Our Ref: AB/71/19/L

Application for Listed Building Consent for Alterations, Extension or Demolition of a Listed Building

Development Rearrangement of 2nd floor bedrooms and provision of additional bathroom.

Location 52 Tarrant Street Arundel

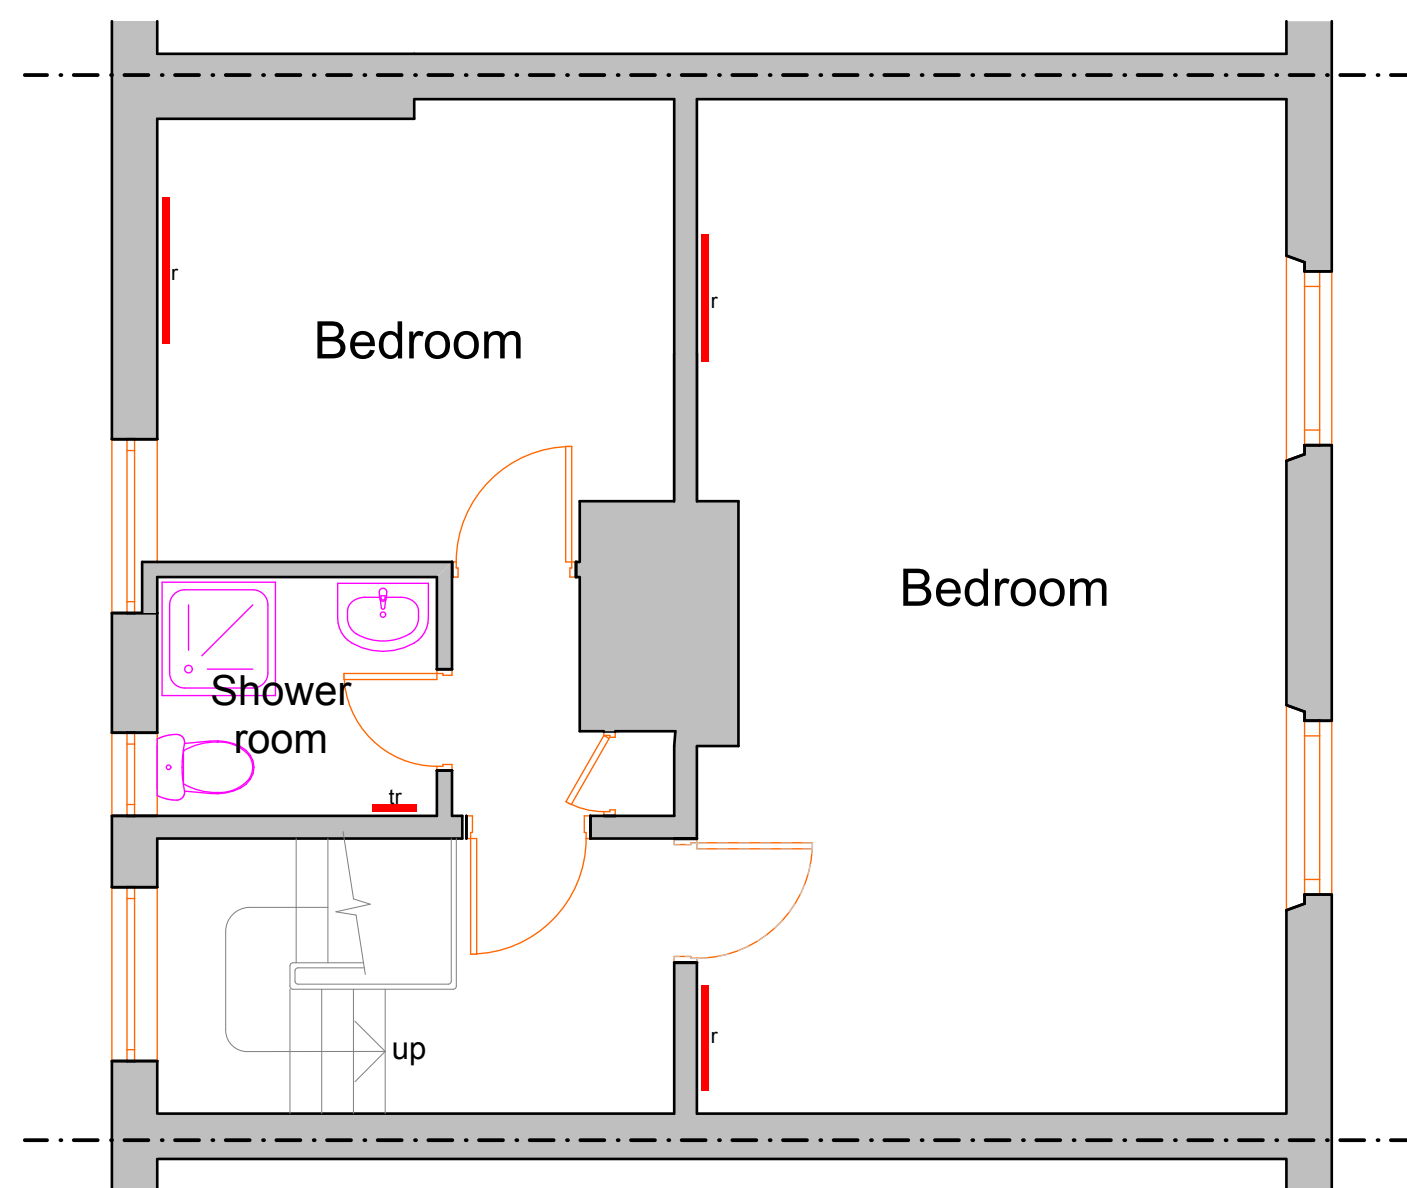
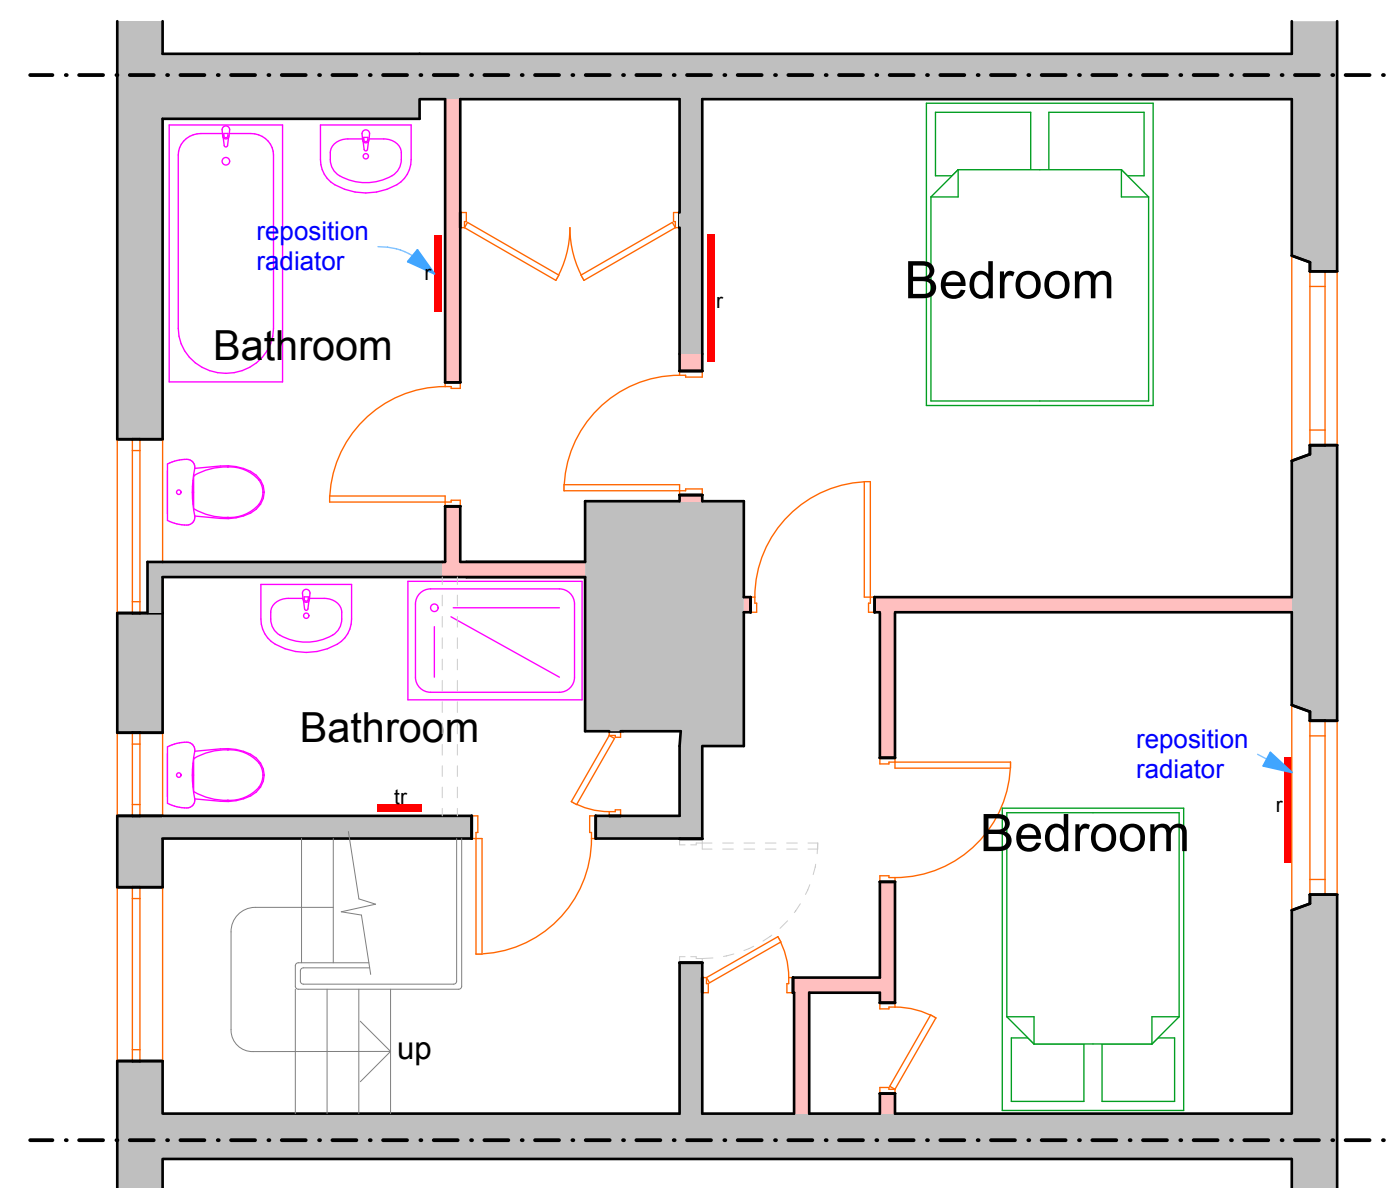
Scale Bar/Dimensions: It is a national requirement that all plans have a scale bar or dimensions to allow for confirmation of the proposed scale. Please amend.
